WEST SUSSEX COUNTY COUNCIL CONSULTATION

TO:	Arun District Council FAO: Anita Gardner
FROM:	WSCC - Highways Authority
DATE:	23 May 2019
LOCATION:	Land between Ashurst and Badgers, Ham Manor Way Littlehampton BN16 4JQ
SUBJECT:	A/55/19/PL Construction of 1 No. new two storey house (resubmission following A/31/19/PL). This application is a Departure from the Development Plan & affects a Public Right of Way.
RECOMMENDATION:	Advice

Site Plan (1:200)

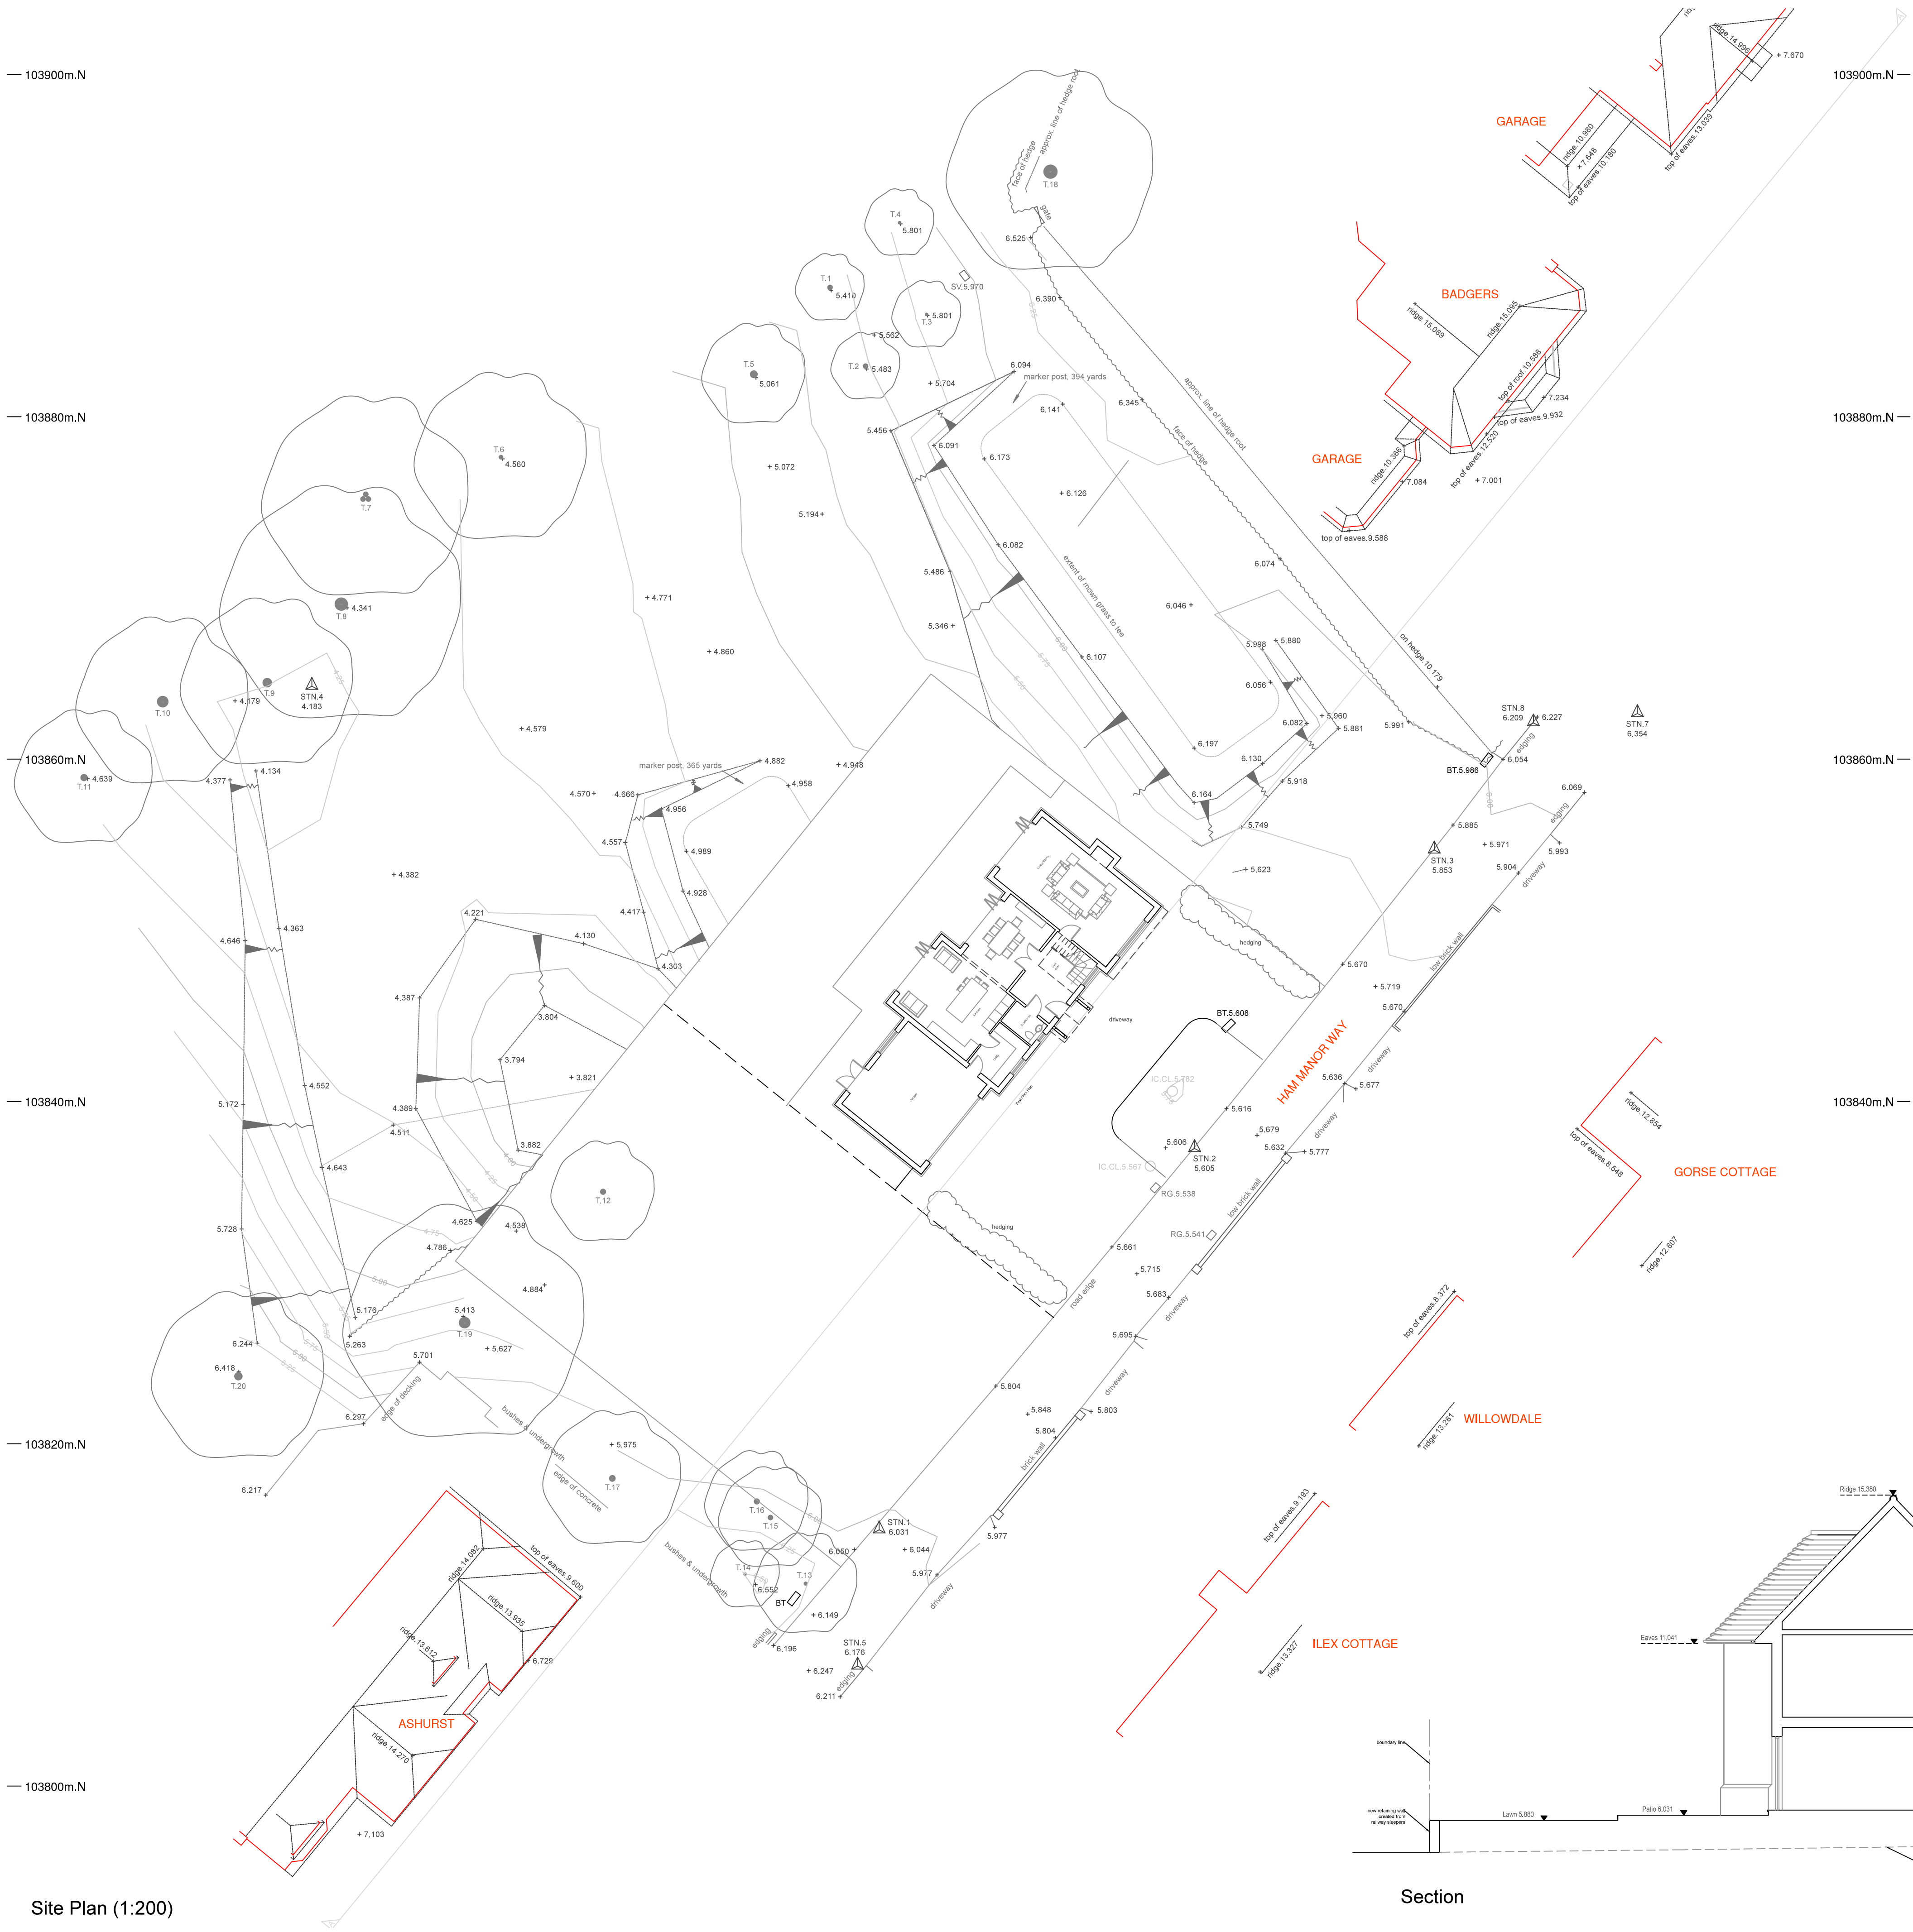
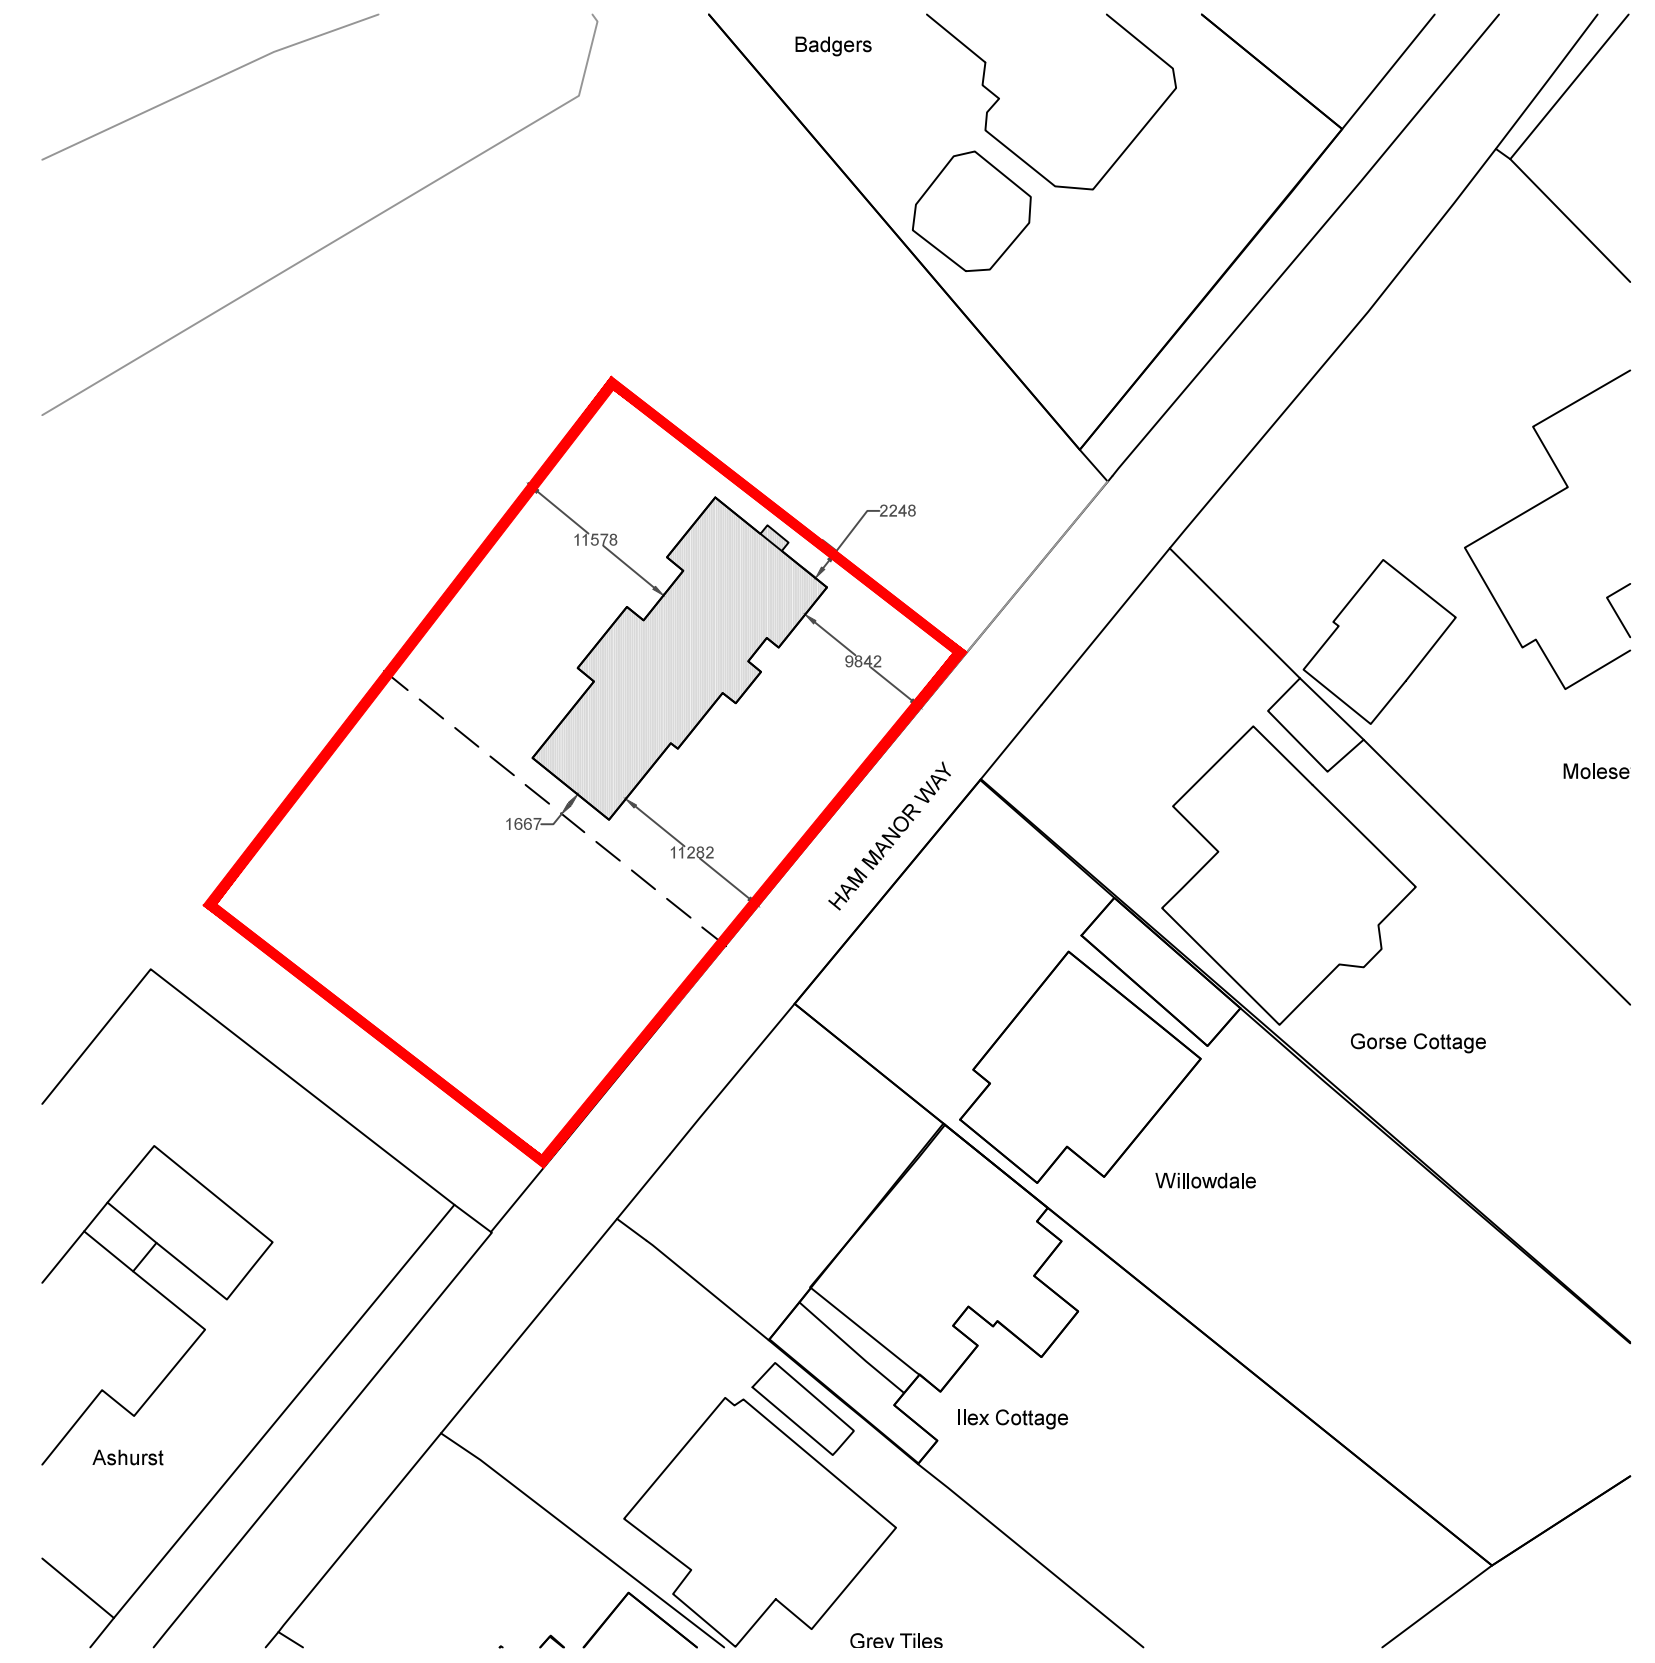
From an inspection of the proposed plans two openings will be created for vehicle access creating an in/out drive. The applicant should gain the permission of the proprietor of the private road to carry out the site access works. I would advise that the garage is at least 6m depth to allow for secure bicycle storage and car parking. The LPA may wish to secure details of car and bicycle parking via condition.
